April 18, 2024

Project: 4700 Eubank Development
4700 Eubank Blvd NE
Subject: TCL Certification for F21-D073
30-Day Temporary Certificate of Occupancy

TRAFFIC CERTIFICATION

A1 SITE PLAN
1" = 20'-0"

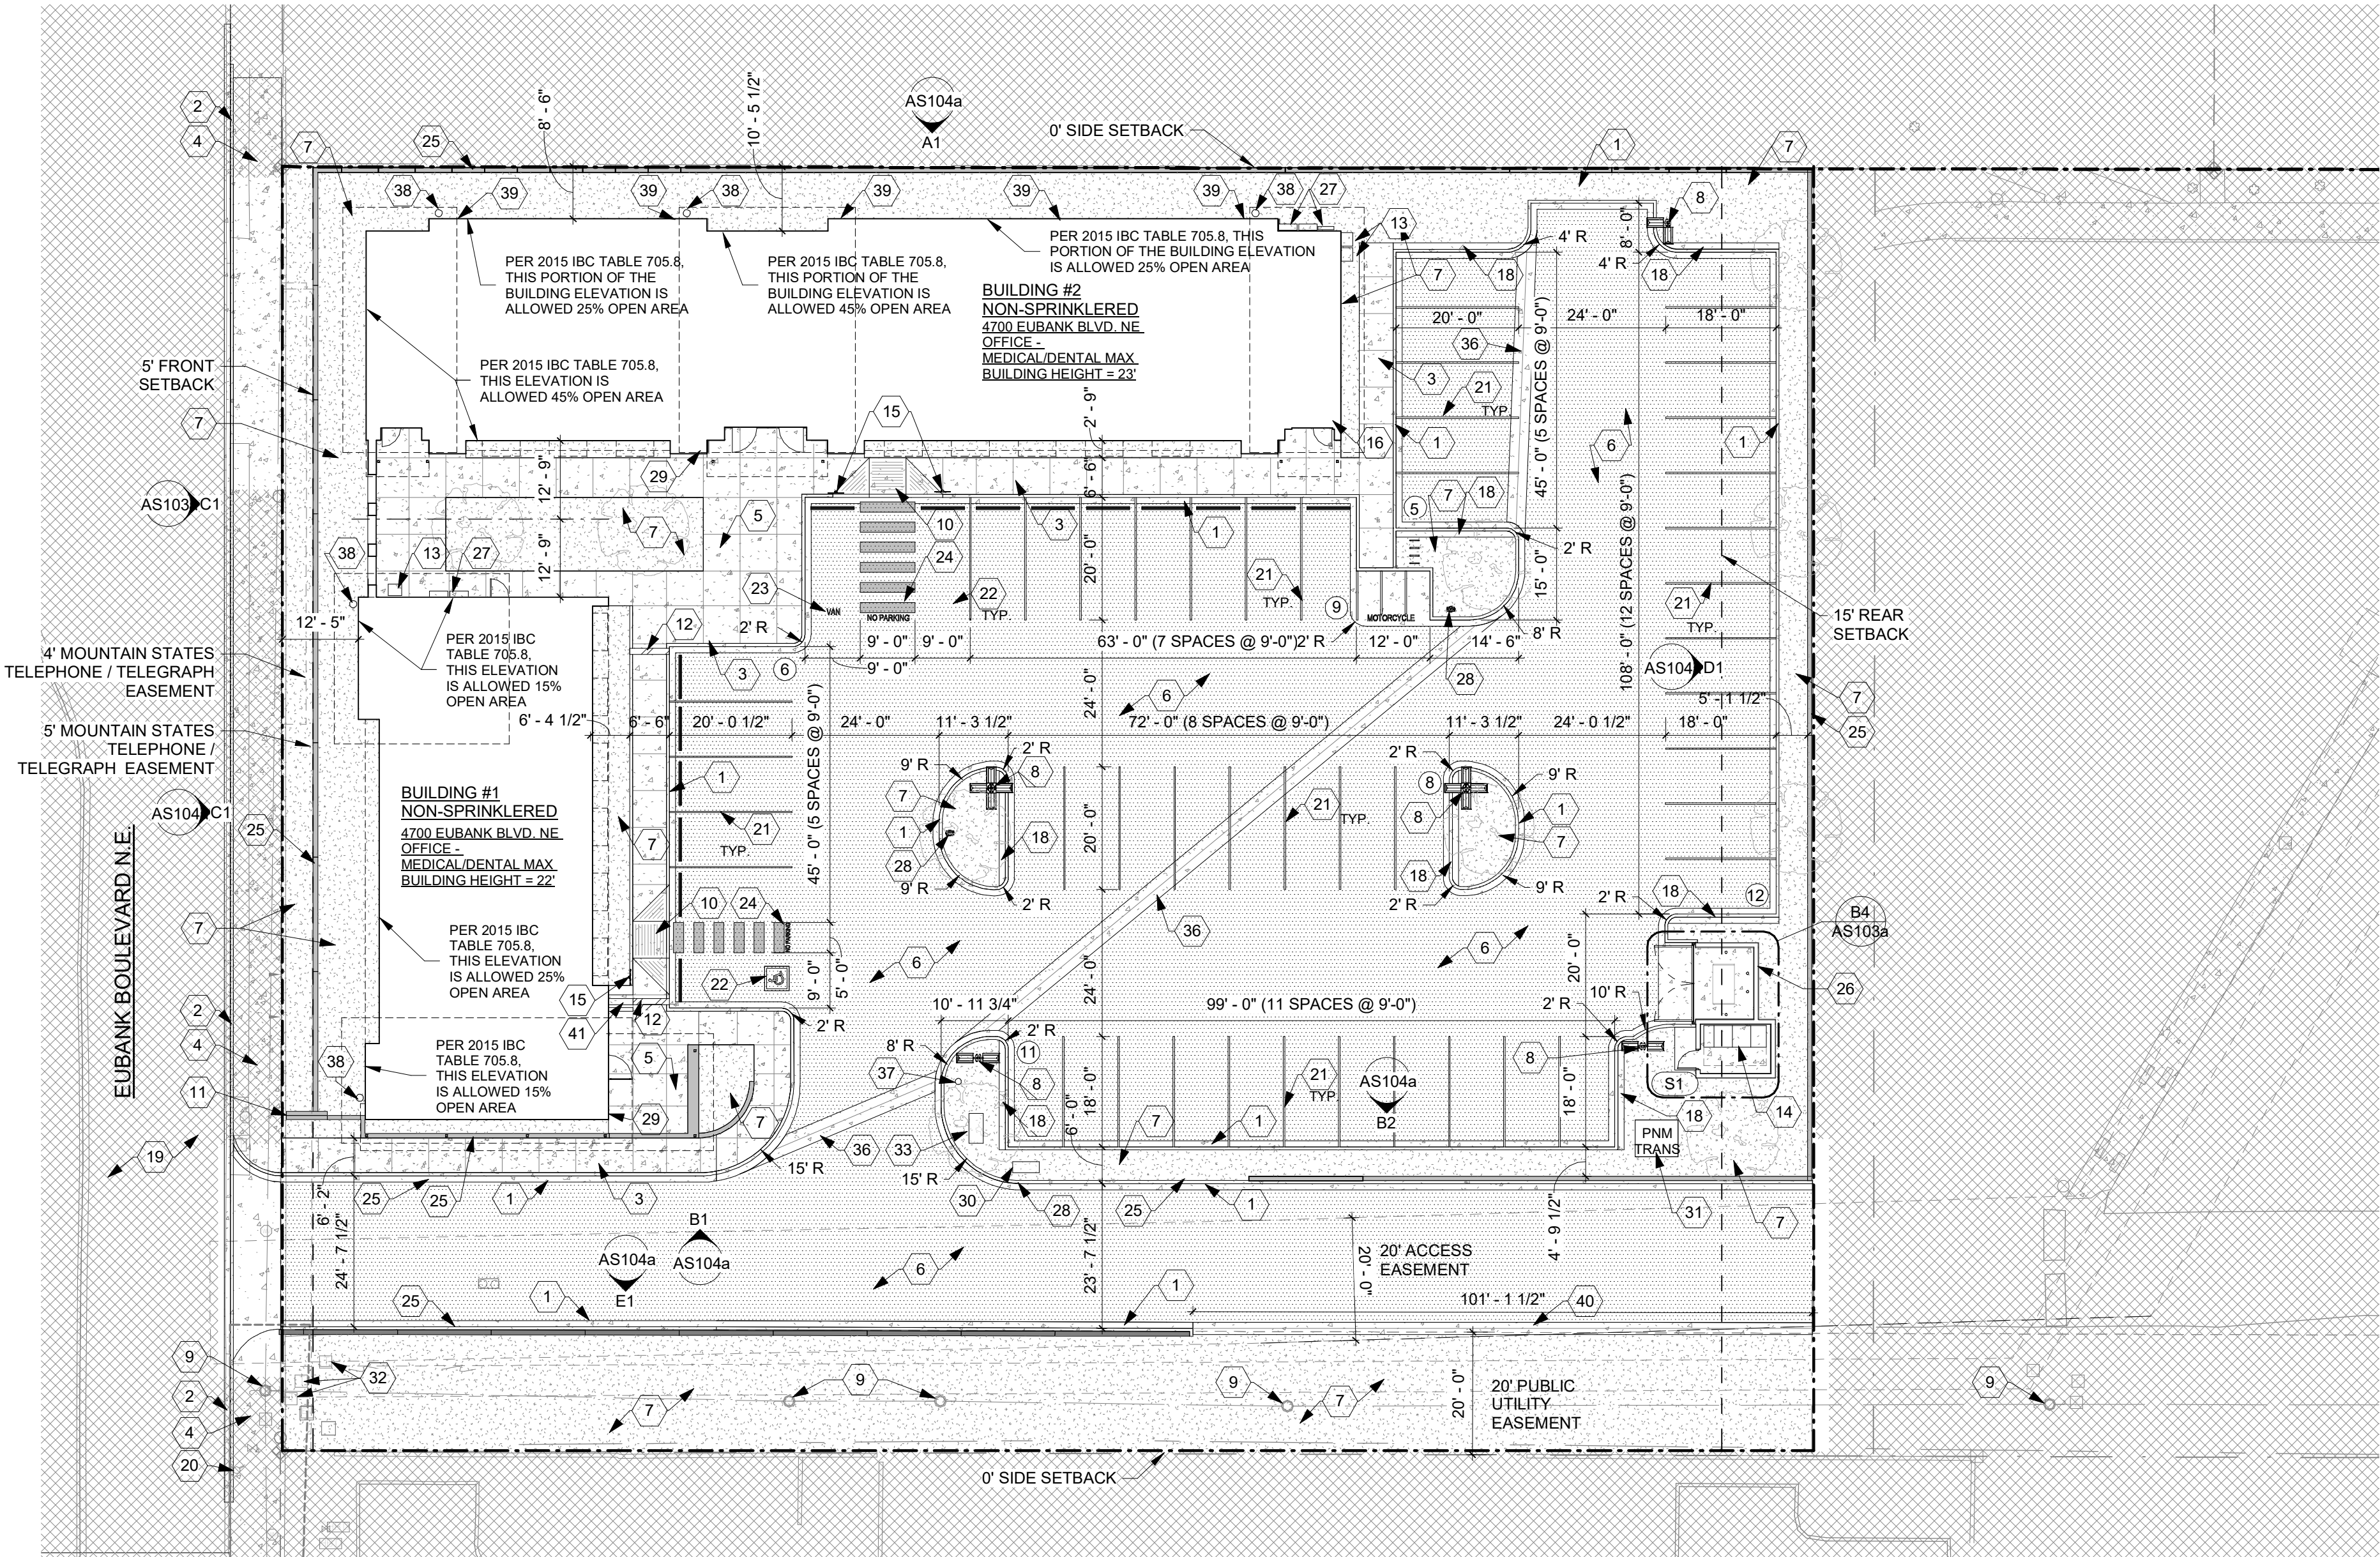
- Please install the ADA signs, The ADA accessible parking sign must have the required language per 66-7-352.4C NMSA 1978 "Violators Are Subject to a Fine and/or Towing." Please call out detail and location of signs.

- Install the Motorcycle parking sign.

- Please see image below of the installed ADA accessible signage with the required language.

- Please see image below of the installed Motorcycle parking sign.
